**CITY OF ALBUQUERQUE
PLANNING DEPARTMENT
May 15, 2013
DRB Comments**

ITEM # 9

PROJECT # 1001568

RE: Tracts B & C, Lands of Haddaway

EXHIBIT
TRACT C
LANDS OF HADDAWAY
CITY OF ALBUQUERQUE
BERNALILLO COUNTY, NEW MEXICO
JULY, 2012

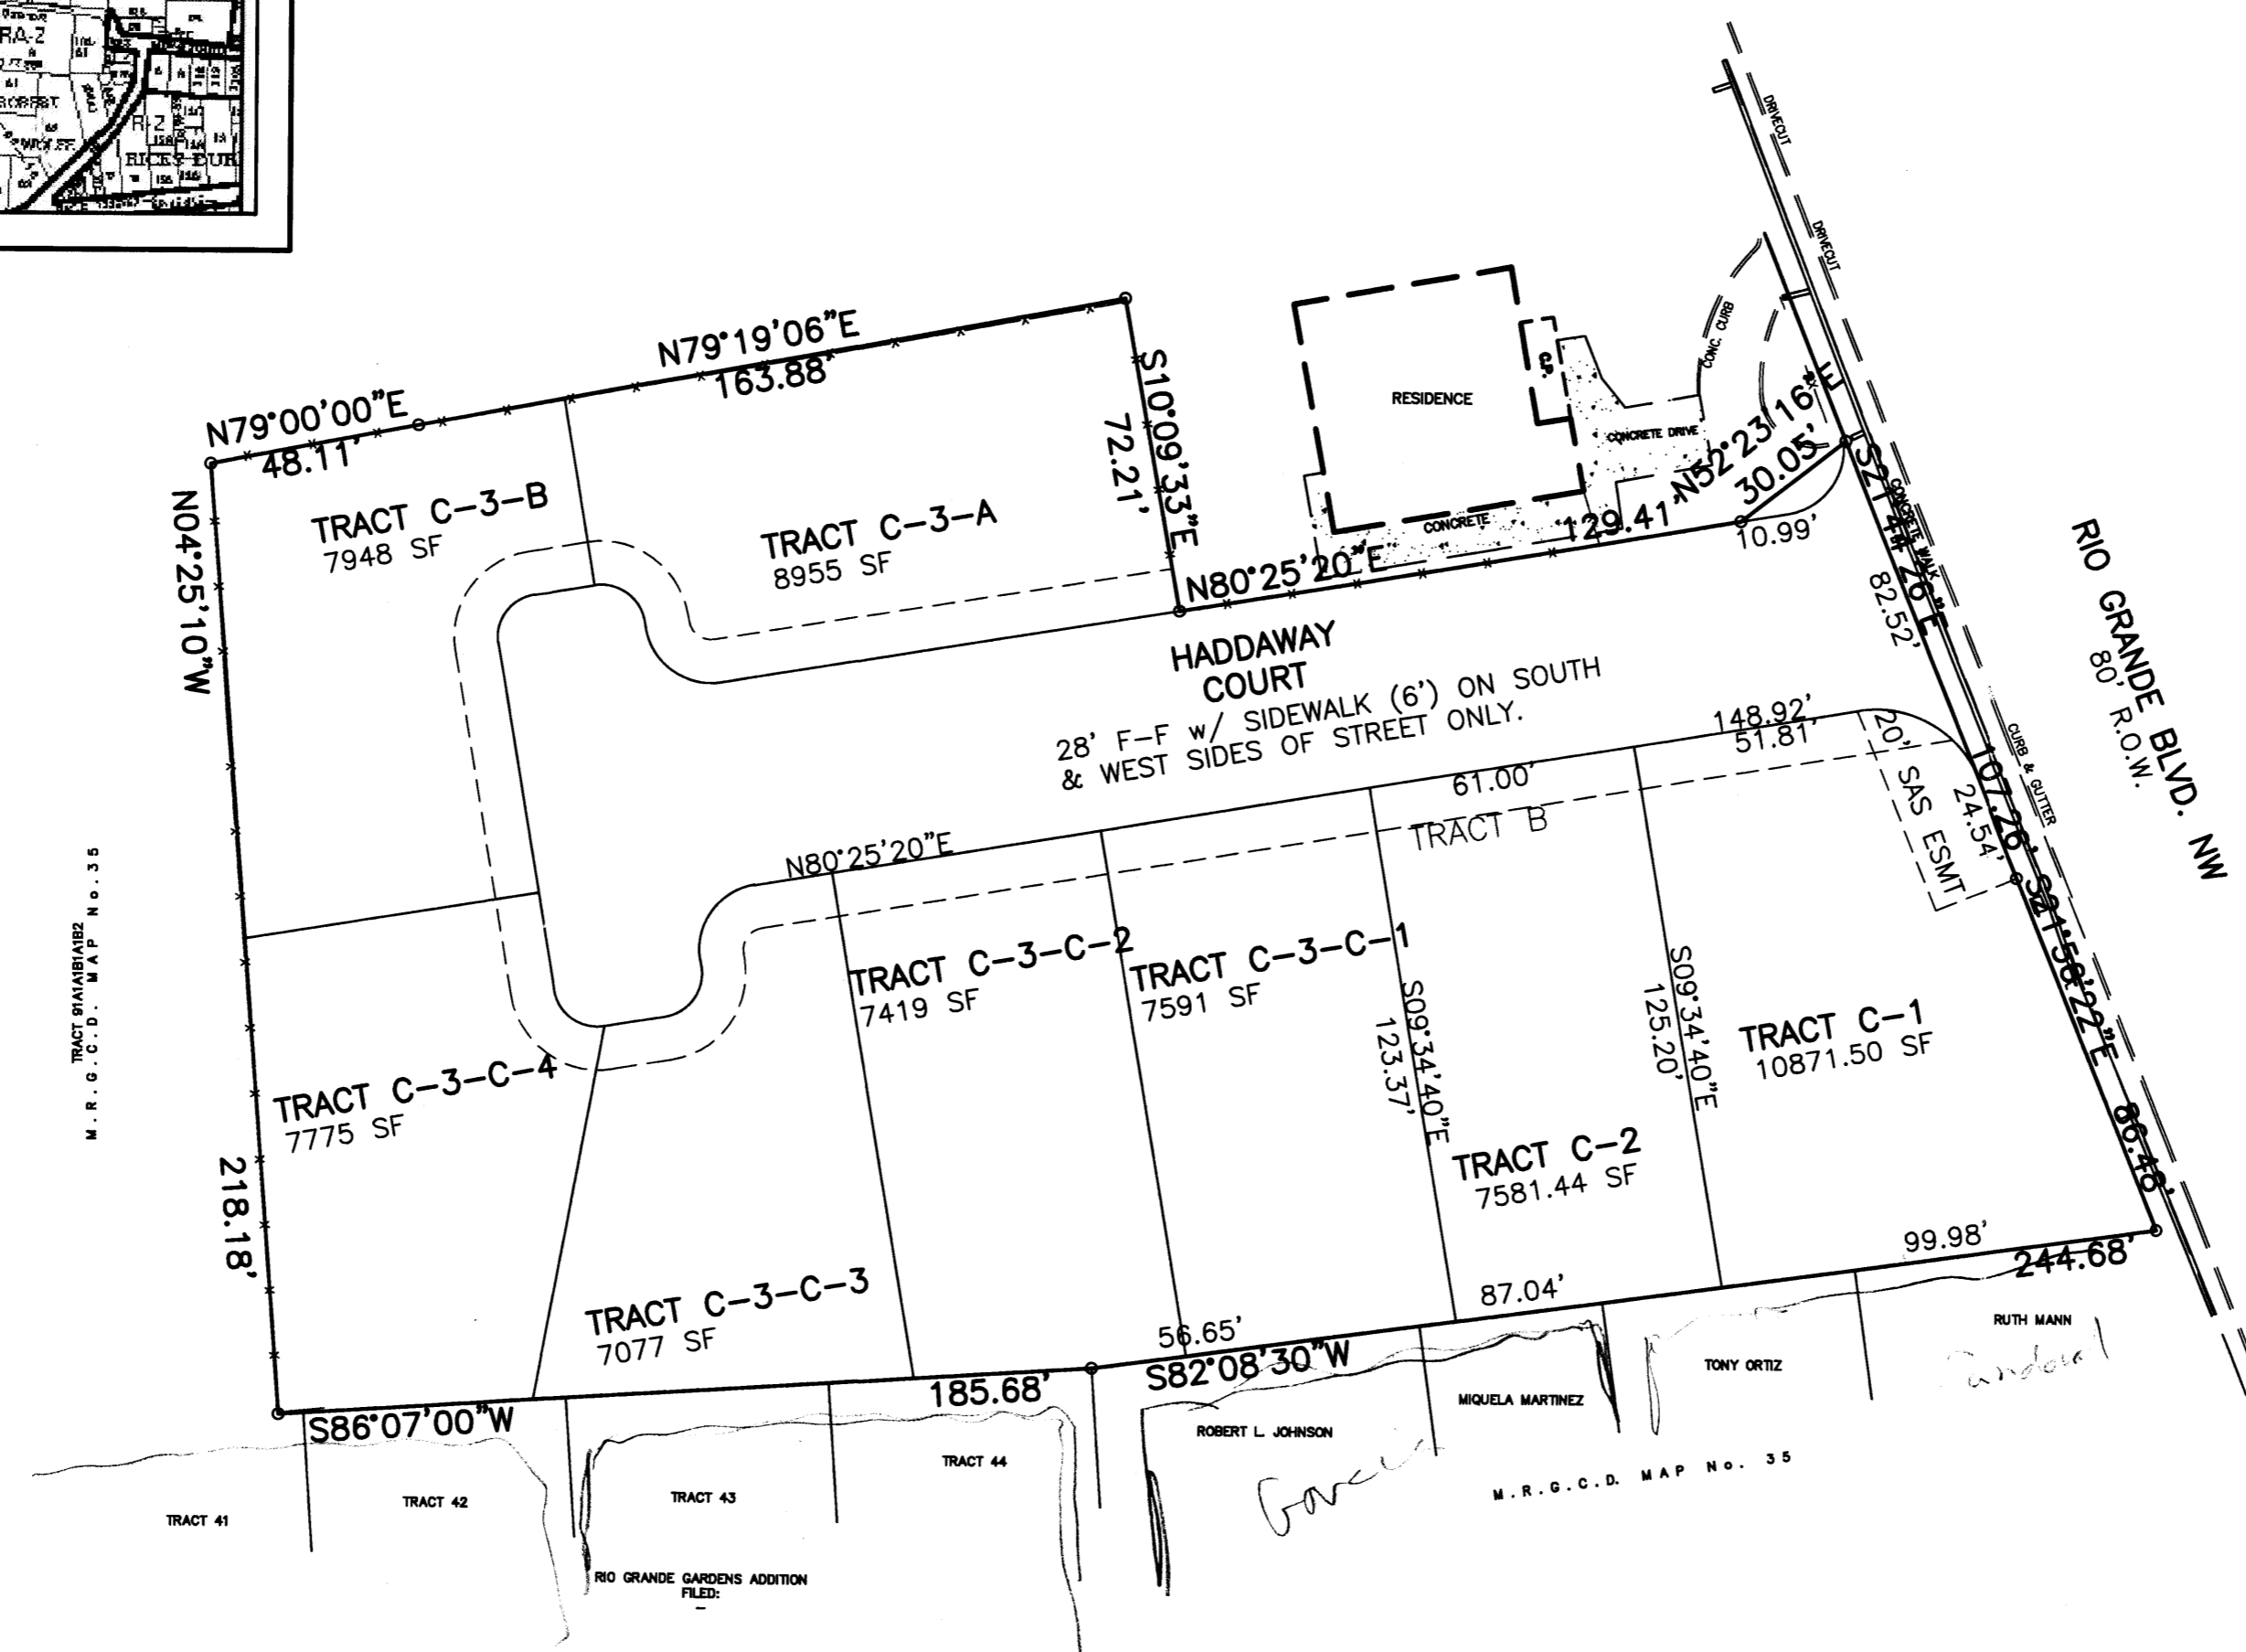
Please provide correct scale for Sketch Plat and Exhibit Tract C (1"=40'). Zoning for the site is established via the Los Duranes Sector Development Plan whereby Tract C is SU-2/ LD RA-2 (minimum 10,890 sq ft net lot area) and Tract B is SU-2/ LD R-1 (minimum 10,890 sq ft net lot area); proposed subdivision would require a Sector Plan and Zone Map amendment. The site is also subject to the Rio Grande Boulevard Corridor Plan, which has additional design regulations as well as policy and regulations for rezoning.
